Rezoning Transportation Analysis

Petition Number: 2020-026

Revision Log:	Date	Description
	03-25-2020	First Review
	04-20-2020	Second Review

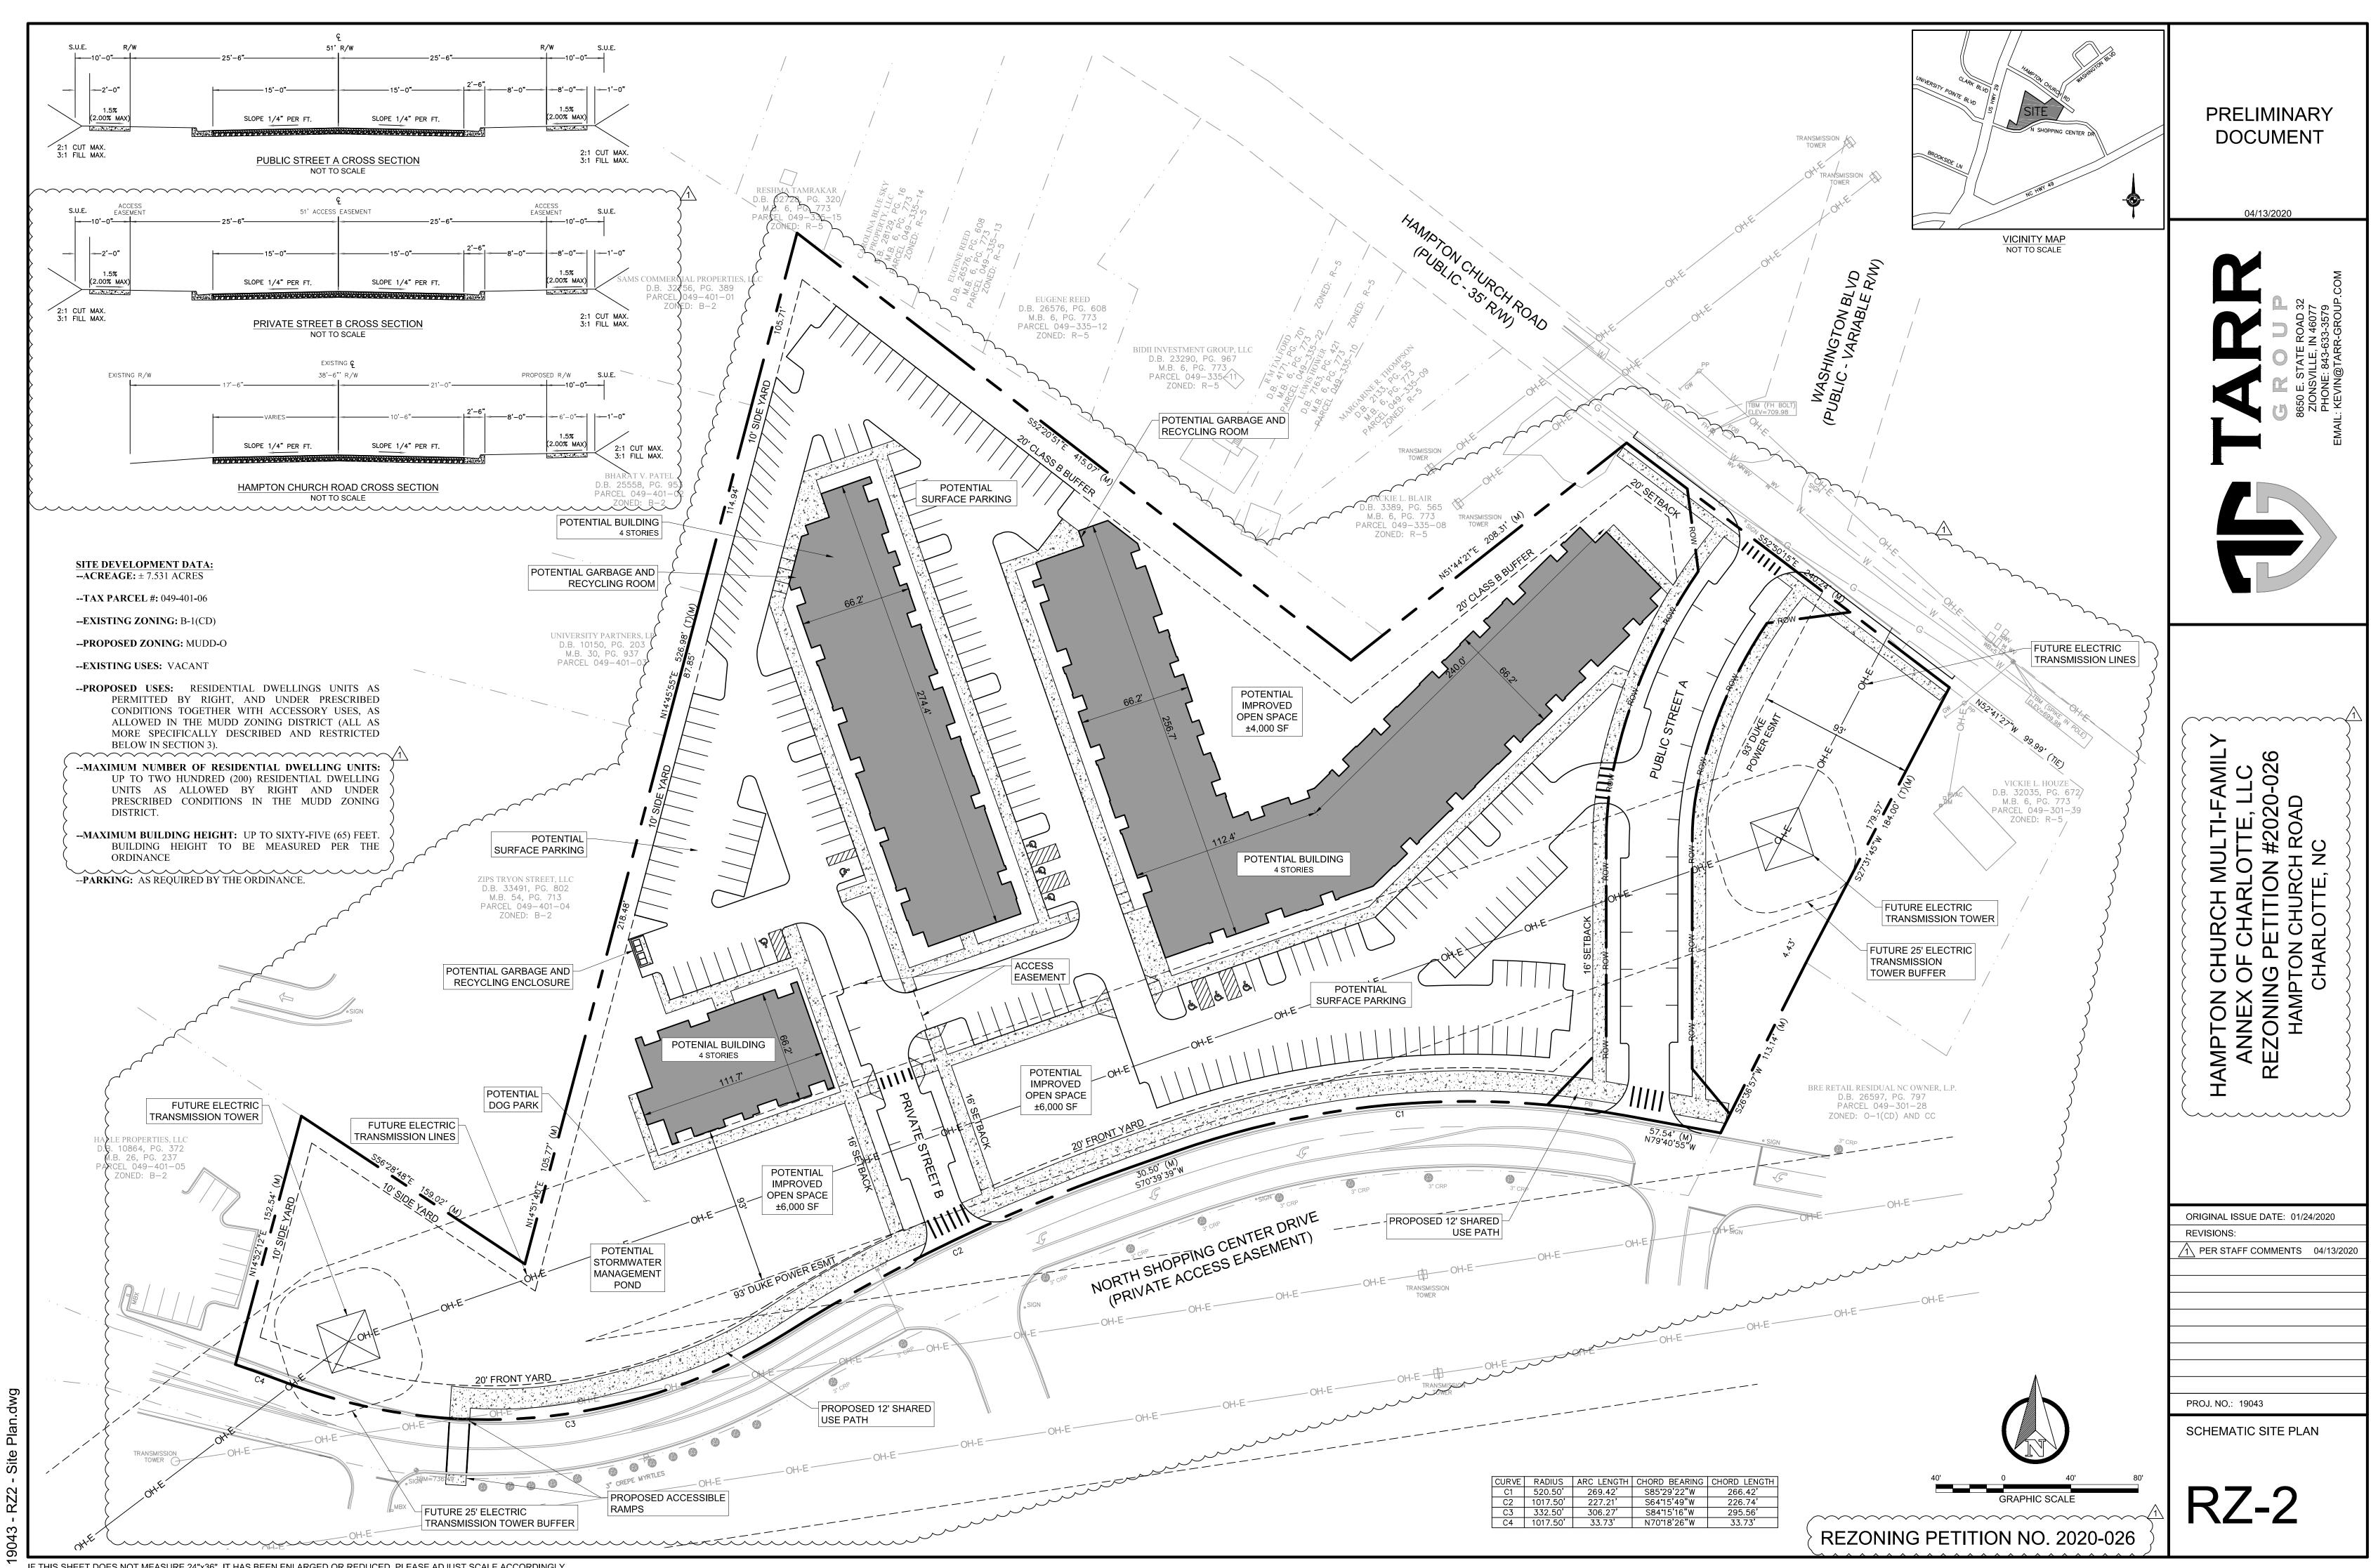
5. The petitioner should revise the site plan and conditional note(s) to align the proposed street and driveways across the street to provide a safer access. (Revised on 04-17-220)

6. The petitioner should revise the site plan to add a note specifying dedication and fee simple conveyance of all rights of way to the City before the site's first building certificate of occupancy is issued. CDOT requests right of way set at 2' behind back of sidewalk where feasible.
7. The petitioner should revise the site plan to add a note specifying all transportation improvements will be approved and constructed before the site's first building certificate of occupancy is issued. The petitioner may phase transportation improvements if said improvements and phasing are explicitly described in site plan notes.
8. **Resolved** - Sample format for comment that is resolved
